Reference No:	2023/62/92353/W
Site Address:	9, Springwood Hall Gardens, Springwood, Huddersfield, HD1 4HA
Description:	Erection of two storey side extension and single storey rear extension with flat roof canopy
Recommending Officer:	Lucy Taylor

Officer Report.

Reference: 2023/92353

Proposal: Erection of two storey side extension and single storey rear extension with flat roof canopy

Drawing Title
Proposed Elevations

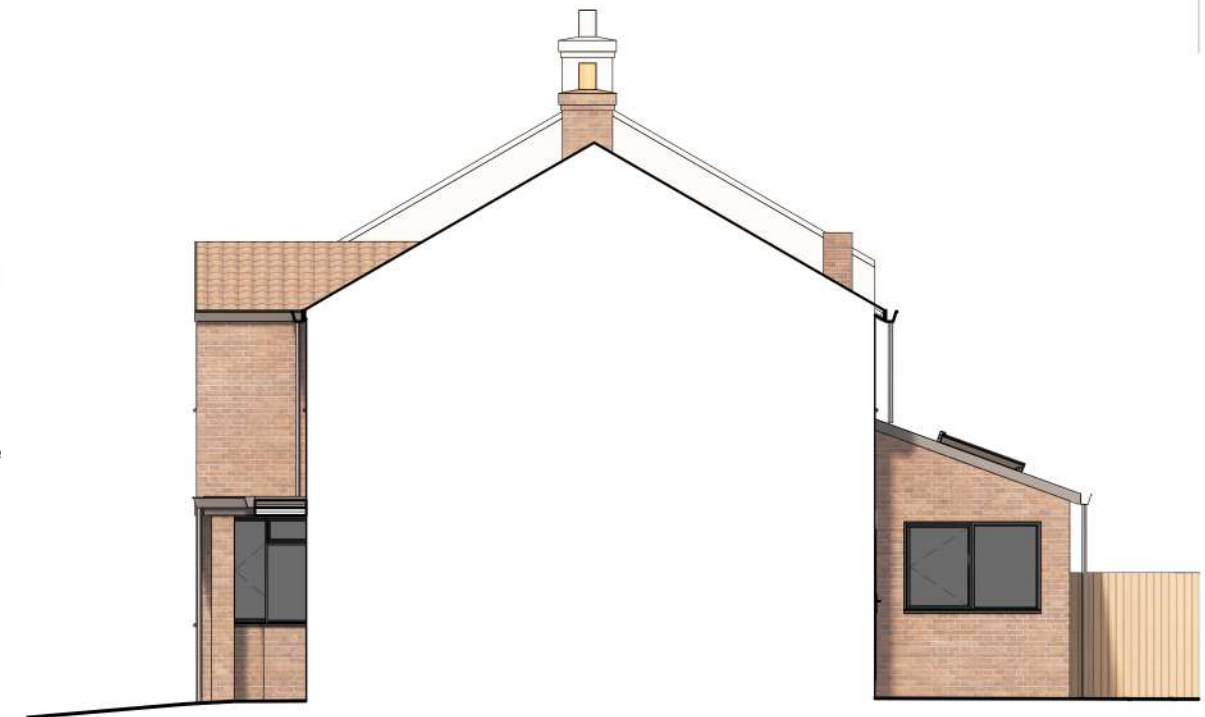
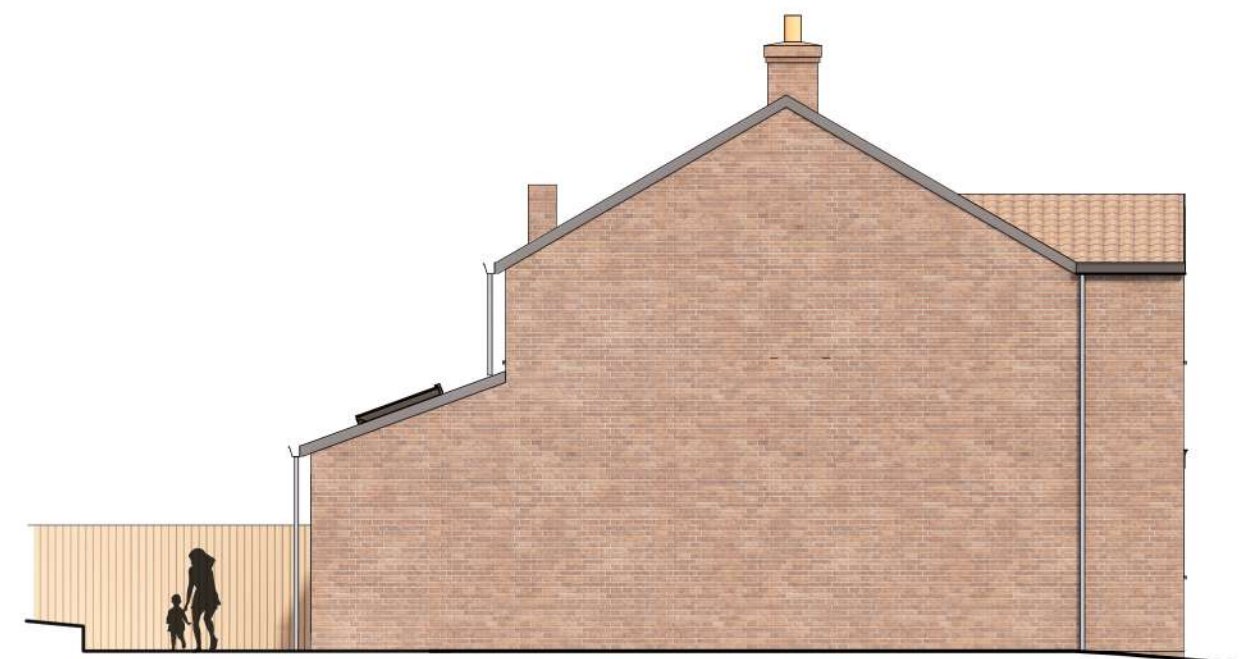
The design of the proposed two-storey side extension to 9 Springwood Hall Gardens is contrary to the design principles of the House Extensions and Alterations SPD as set out above. The two-storey side extension would not appear as a subservient addition to the host property, presenting an undue extent of additional bulk/massing to the front and side of the dwellinghouse.

The projection of the side extension would retain a separation distance of 0.8 metres from the northern boundary, the extension would not be set down from the ridge of the host property and the extension would project forward of the principal elevation of the host property by 1.45 metres. Cumulatively, these

two design factors would result in the extension appearing cramped and overtly oppressive within the streetscene.

The single storey rear extension proposes one window to the southern side elevation. This window would face towards the shared boundary with No. 11 Springwood Hall Gardens and the floor plans suggest that it would serve a dining kitchen (e.g. kitchen with an open shared dining room). This area internally is defined as been a habitable room within the House Extensions and Alterations SPD. As such, given that this window would be directly adjacent to the rear amenity space of No. 11, it is concluded its erection could result in undue impacts with regard to neighbouring privacy and overlooking.

The proposal is considered to have an unacceptable visual impact upon the host property and wider locality as a result of the design of the two-storey side extension.

The proposal is also concluded to have an unacceptable impact upon the residential amenity of the occupiers of No. 11 Springwood Hall Gardens. Whereby, as a result of the single storey rear extension, the occupiers of this neighbouring property would experience an unacceptable level of overlooking.

Proposed Street Elevation

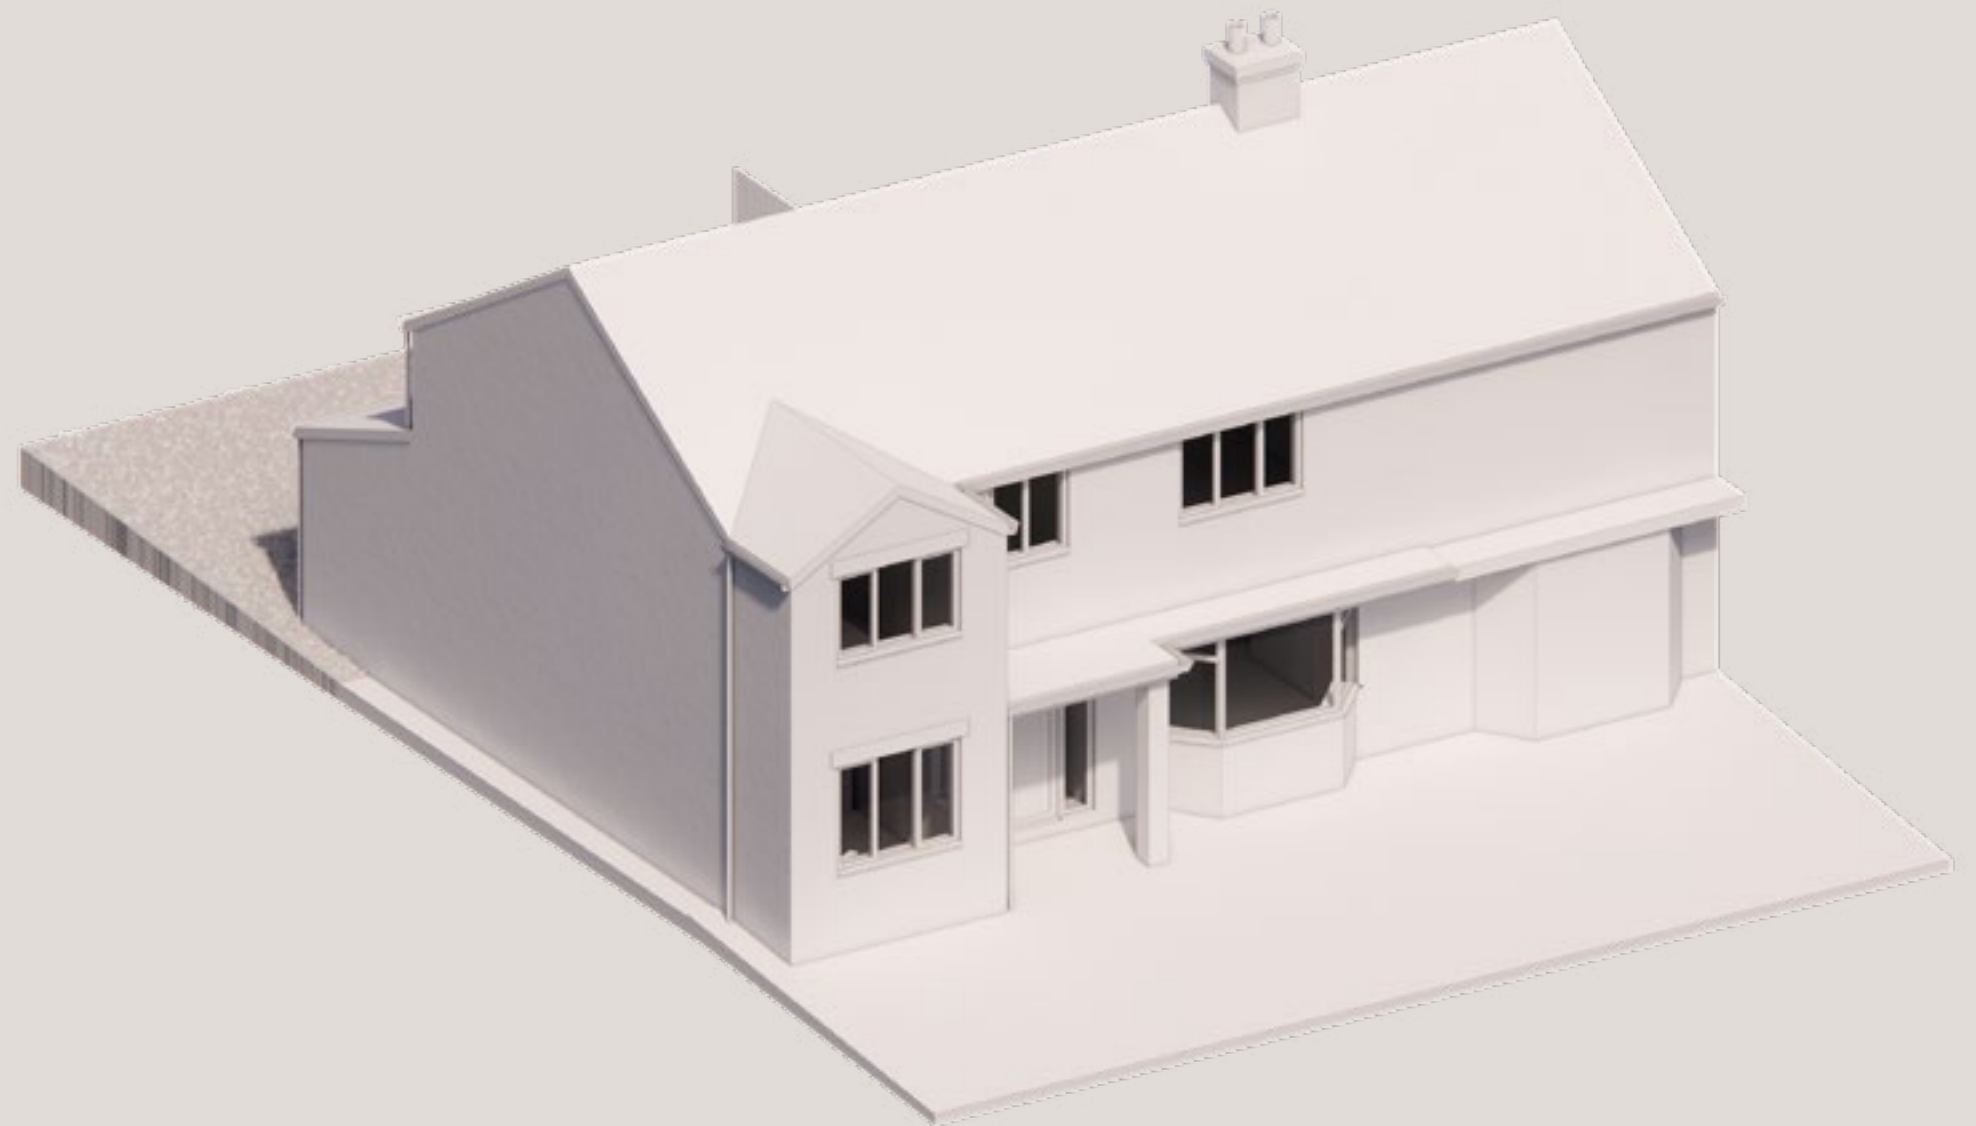
Whilst officers note that various two-storey side extensions have been erected within the streetscene, which project forward of the principal elevation of the host dwelling, these are not considered to afford significant weight to the determination of this current planning application. The reasons for this are because the extensions are to either a different property type (e.g. detached properties) and/or where granted prior to the adoption of the House Extensions and Alterations SPD. It should be noted that the two-storey side extension to No. 13 Springwood Hall Gardens sits flush with the principal elevation.
